Recommendation Report for Planning Permission

REF NO:	AL/126/21/PL
LOCATION:	Ryefields Farmhouse Oak Tree Lane Woodgate PO20 3GU
PROPOSAL:	Demolition of existing building and erection of 5no. houses comprising 1no. 4-bed detached, 2no. 4-bed link detached & 2no. 3-bed detached houses with associated access & parking (resubmission of AL/81/21/PL). This site falls within Strategic Site SD5, CIL Zone 1 (Zero Rated).

Fig 4 - Proposed Site Plan

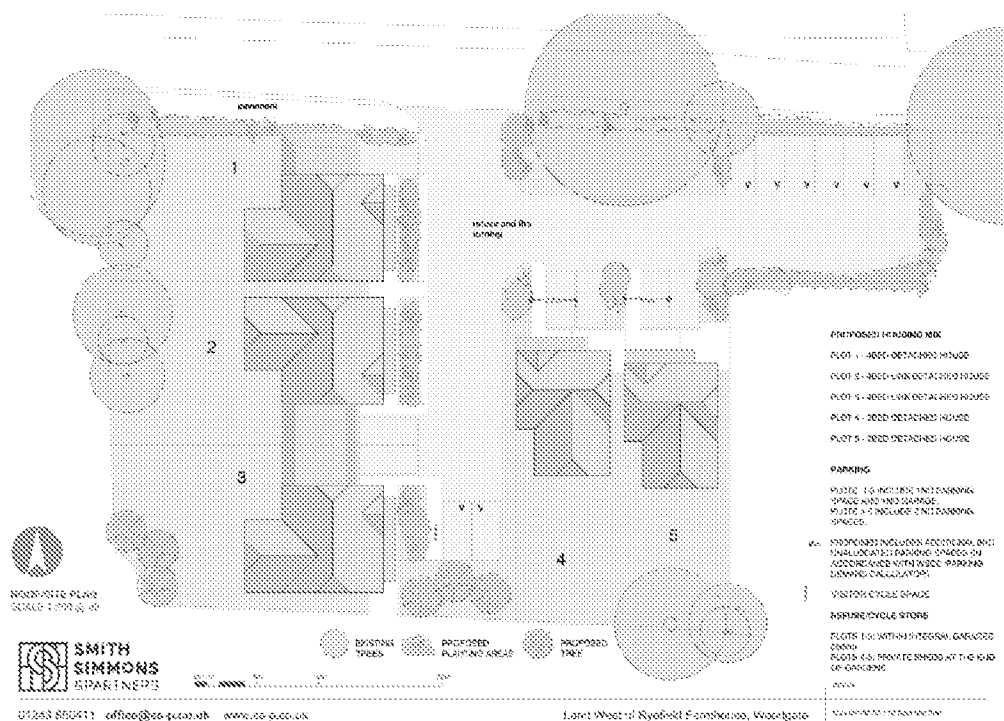
Conversely, the application proposal seeks a different urban form of a cul-de-sac development where the side elevation of plot 1 would be situated some 2.5m from Oak Tree Lane and so would be readily visible from the highway. This would erode the established form, continuity and cohesion of the streetscape along Oak Tree Lane.

The design and layout of the site is further exacerbated through the inclusion of the visitor parking bays along the boundary of Oak Tree Lane, which comprises 6 no. spaces arranged in a bay parking formation. Such a parking arrangement directly conflicts with the established parking layout of residential buildings on Oak Tree Lane, where off-street parking is accommodated forward of the primary elevations of dwellings. These bays are also now sited further east of the actual dwellings (in order to preserve the TPO tree) and will be viewed as being detached from the layout.

refuse and fire
turning

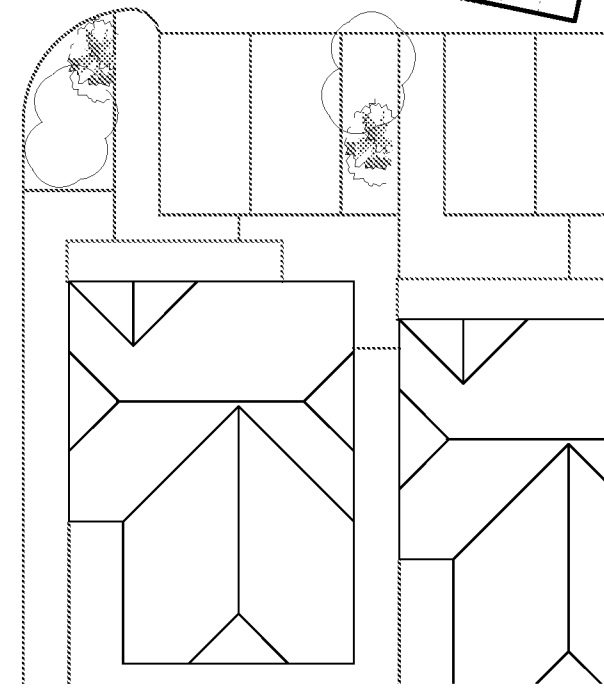
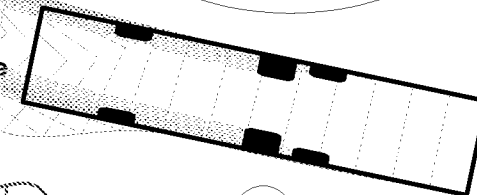
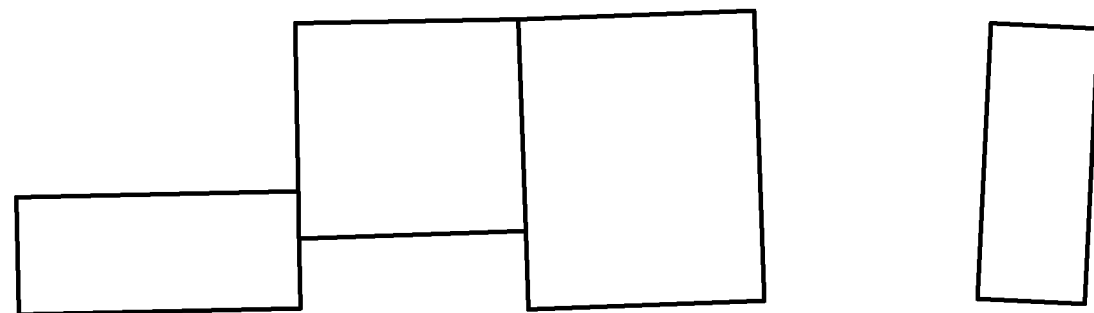
- Given the low number of dwellings, traffic generation and associated impact on the local road network would be low;
- Swept-path diagrams demonstrate that both refuse and fire appliances can enter and leave the site and turn within it;

T02

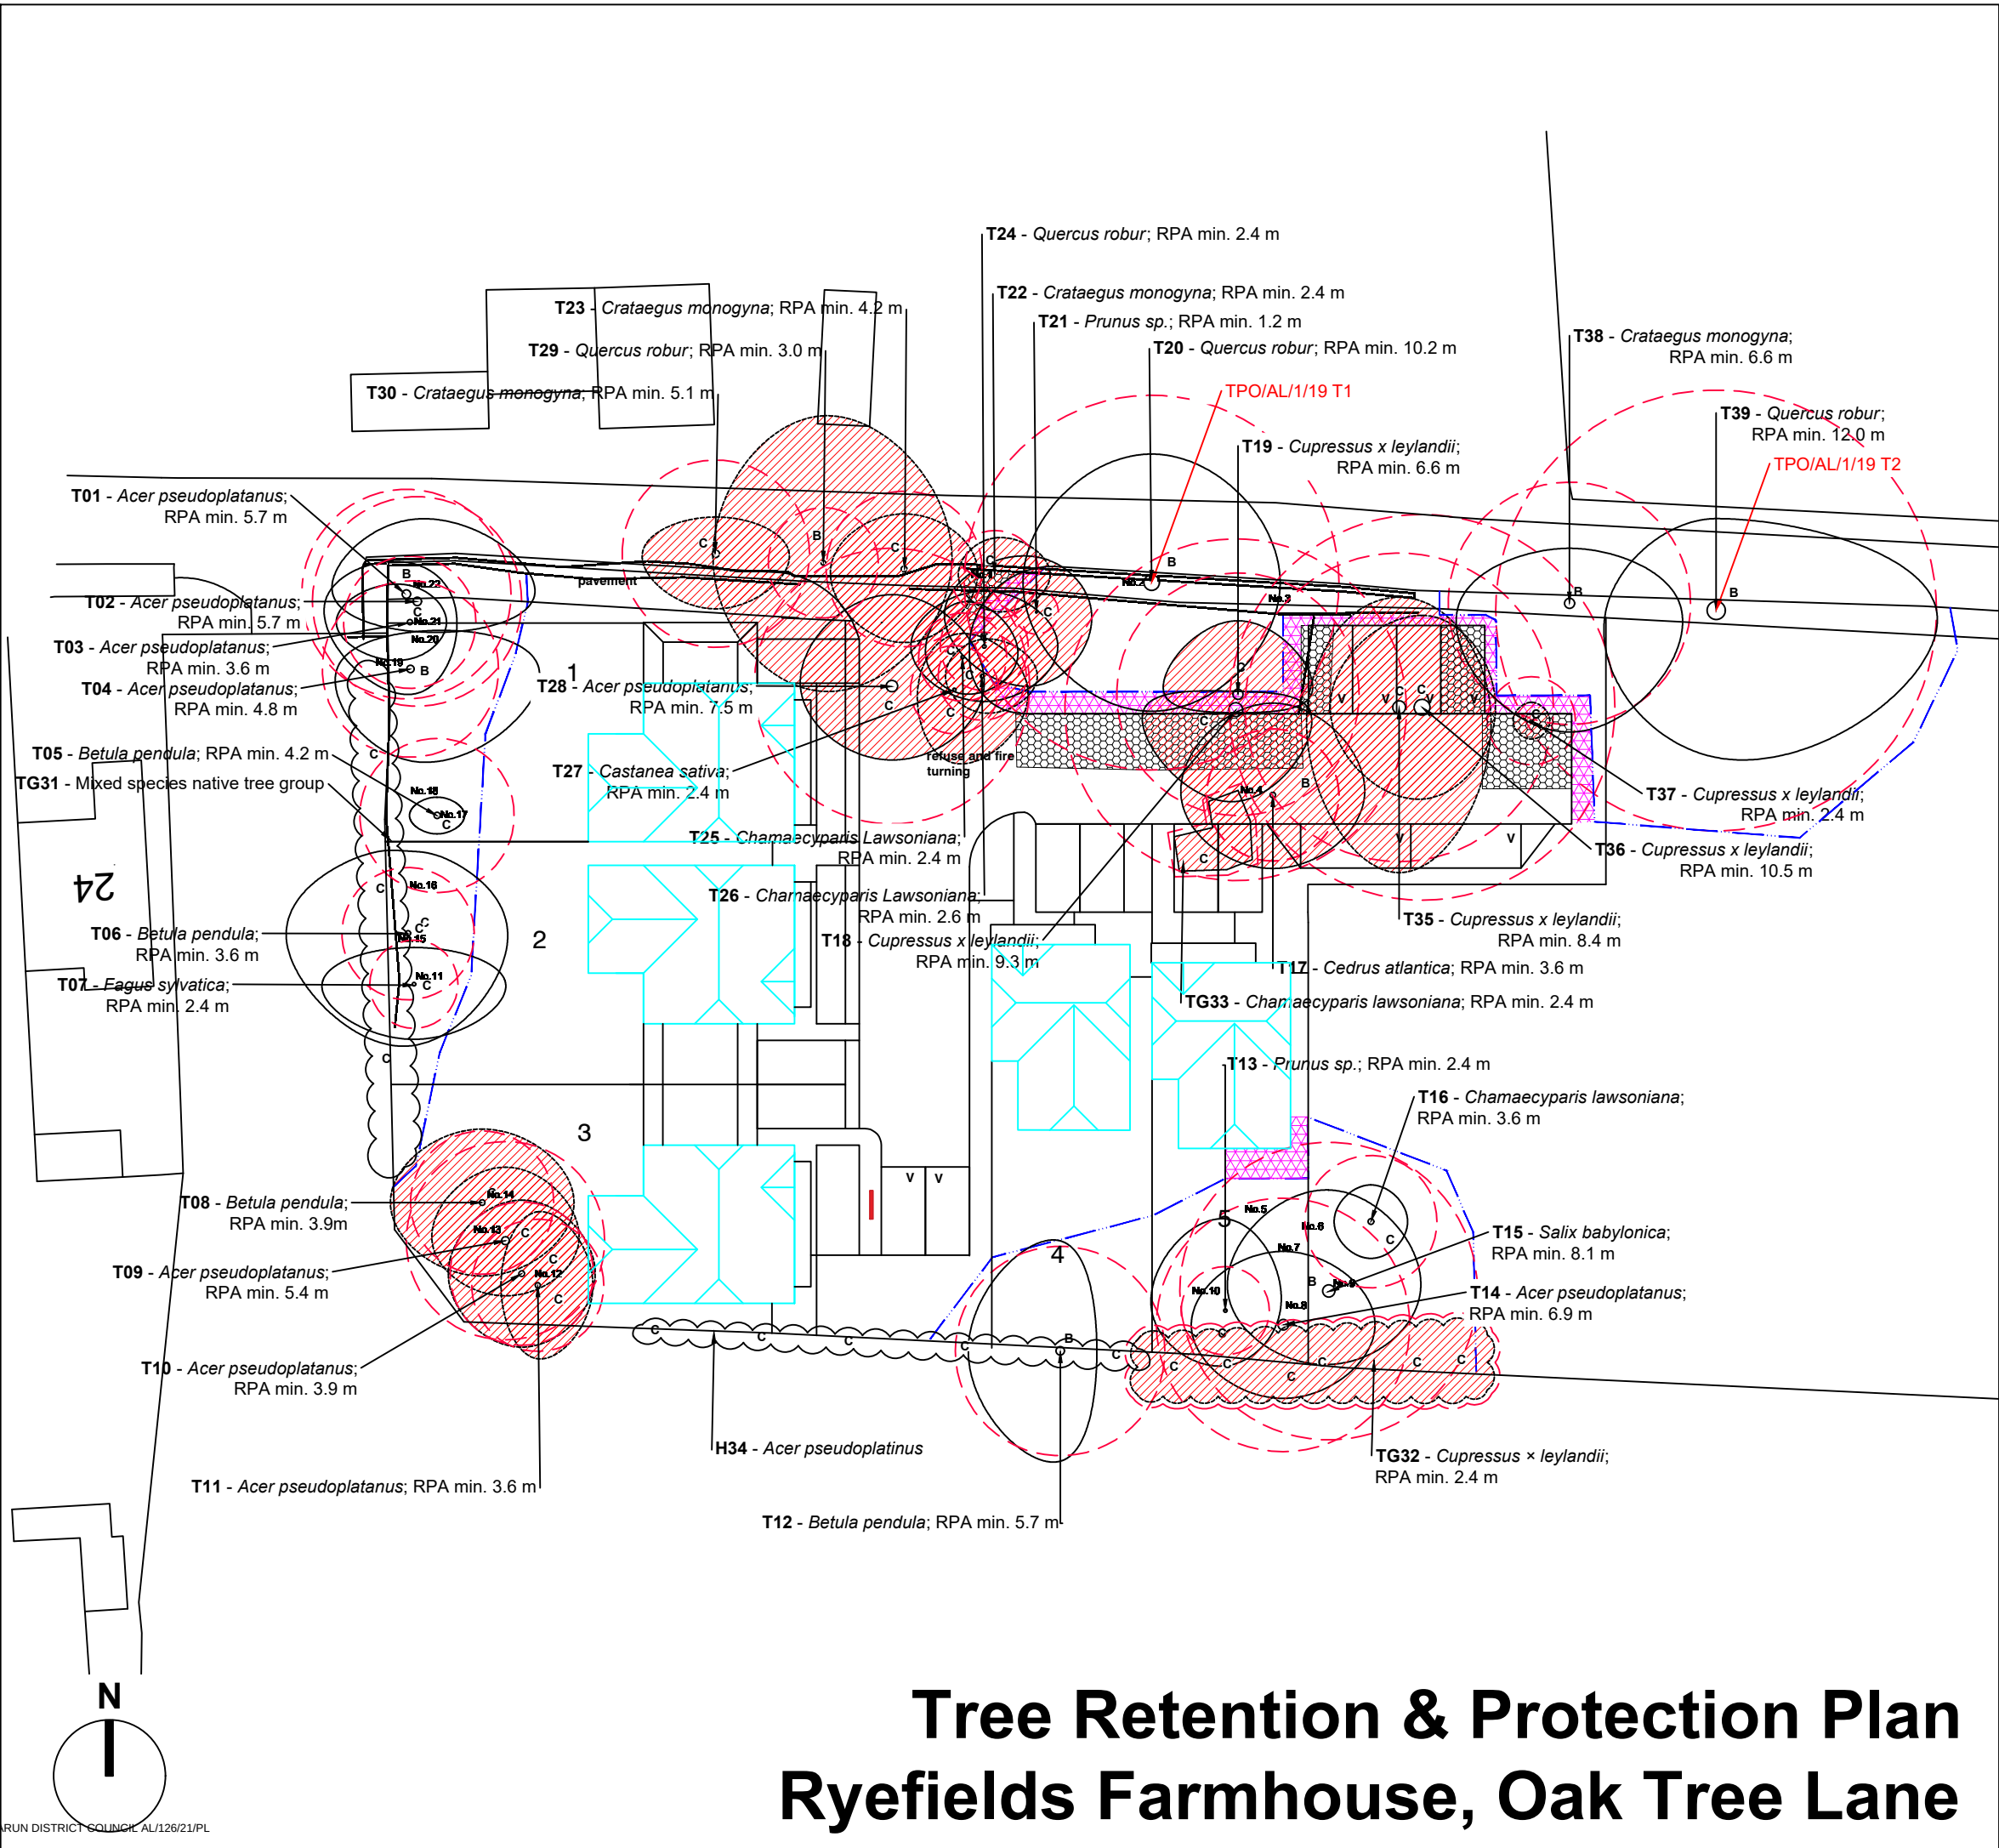
- This latest proposal appears more sympathetic to its predecessor in that it seeks to retain the mature oak (subject of a TPO) T20;
- Unfortunately, both T20 and its companion oak T39 (subject of the same TPO) will be impacted by the installation of a car parking area. A no-dig construction method is to be employed;

- The combined extent of ground protection and no-dig construction areas, as shown on the TRP plan is already extensive;
- Whilst they propose recognised engineering solutions for working in close proximity to retained trees, it must be noted that that element is very ambitious and carries a high risk of accidental damage;

- It is important to consider the greater volume of the oak trees' roots would likely be found within the development site and so any RPA incursion (irrespective of mitigation measures) may be more extensive than apparent on the plans;

- Several trees proposed for removal appear to be off-site and in 3rd party ownership.
